Subject: Retreat at TimberRidge Filing No. 3 Final Plat (SF-22-041)

The Park Operations Division of the Community Services Department has reviewed the Retreat at TimberRidge Filing No. 3 Final Plat development application and has the following preliminary comments of behalf of El Paso County Parks. This application and its recommendations will be presented to the Park Advisory Board for endorsement on February 8, 2023:

The Retreat at Timber Ridge Filing No. 3 Final Plat Review

619 N. Cascade Avenue, Suite 200
Colorado Springs, Colorado 80903 (719)785-0790

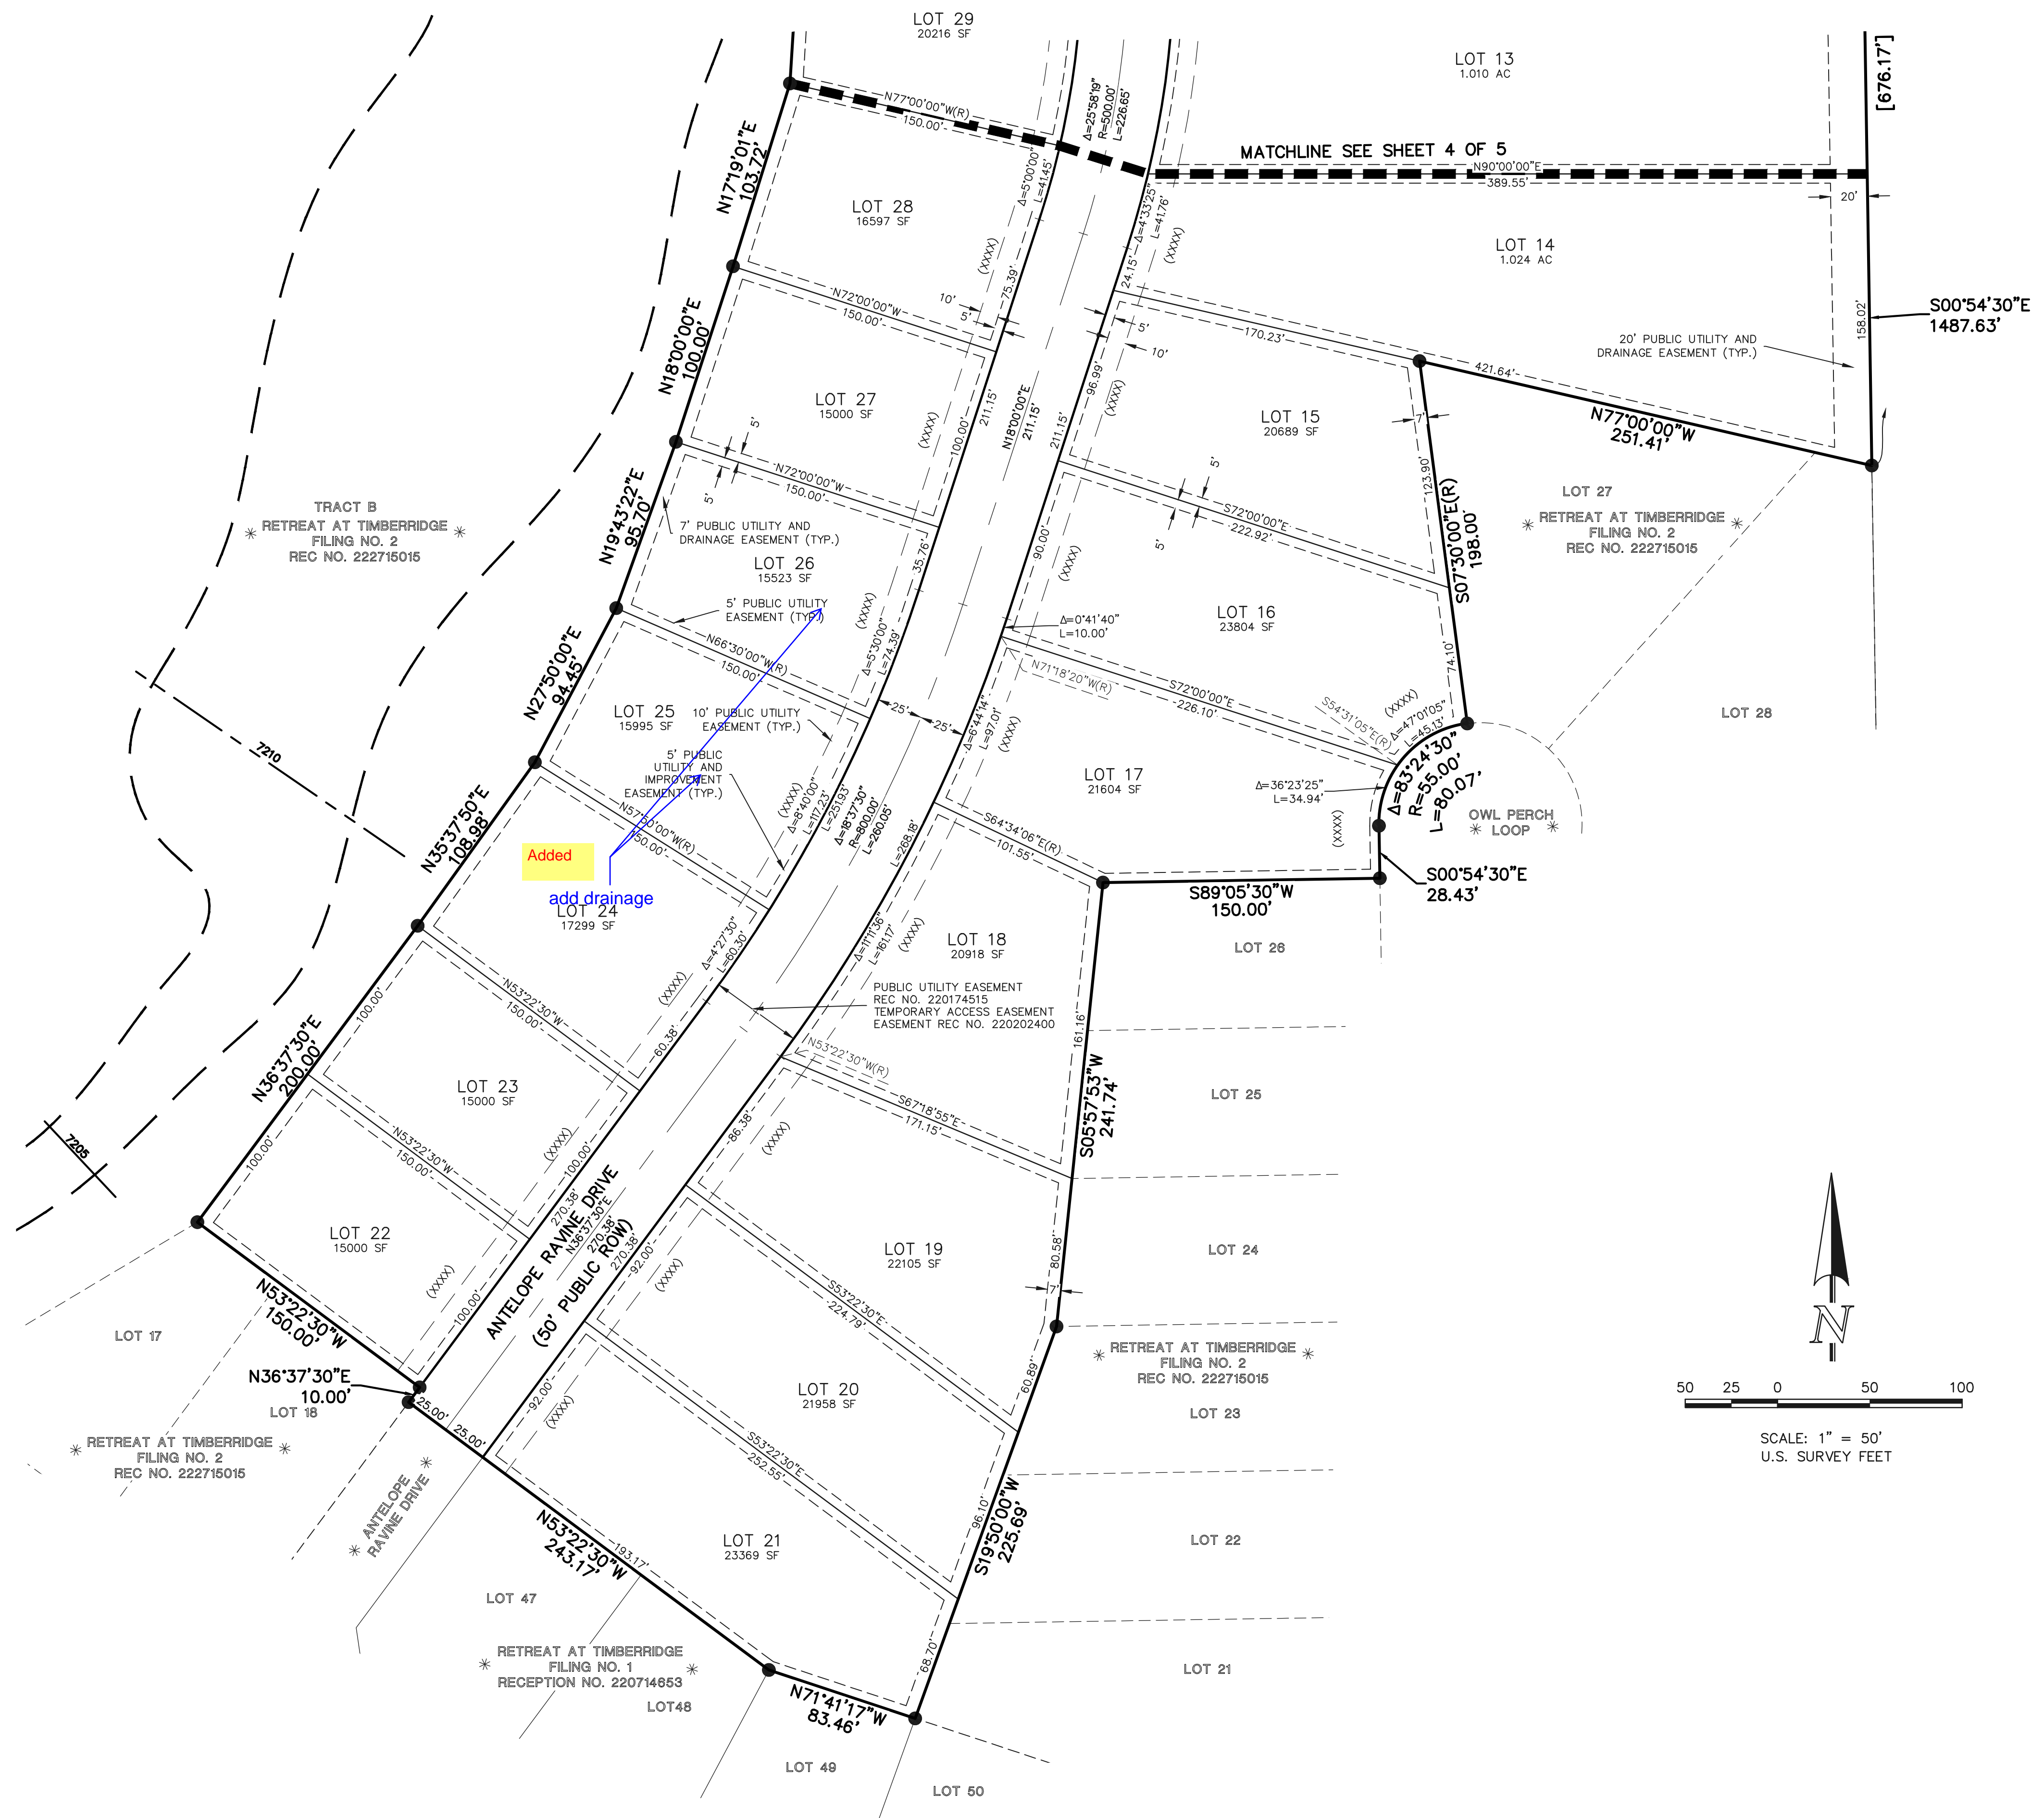
The Retreat at TimberRidge Filing No. 3 Final Plat shows a 30' trail easement dedicated to the Sand Creek Regional Trail, running north-south on the west side of Sand Creek. According to the plat, this trail easement terminates at Arroyo Lane, and no additional trail easements are designated along Arroyo Lane, either east or

"The Park Advisory Board recommends that the Planning Commission and the Board of County Commissioners include the following conditions when considering and/or approving the Retreat at TimberRidge Filing No. 3 Final Plat: (1) provide to El Paso County a 25-foot public trail easement along the west side of the Sand Creek Drainage from the southern plat boundary to Arroyo Lane that allows for public access, as well as construction and maintenance by El Paso County of the Sand Creek Primary Regional Trail, and this easement shall be shown on and dedicated to El Paso County prior to the recording of this Final Plat; (2) provide to El Paso County a 25-foot public trail easement along the south side of Arroyo Lane outside of the public Right-of-Way, from the eastern plat boundary to Vollmer Road that allows for public access, as well as construction and maintenance by El Paso County of the Arroyo Lane Primary Regional Trail, and this easement shall be shown on and dedicated to El Paso County prior to the recording of this Final Plat; (3) require fees in lieu of land dedication for regional park purposes in the amount of \$15,180 and urban park purposes in the amount of \$9,570 to be paid upon recording of this Final Plat."
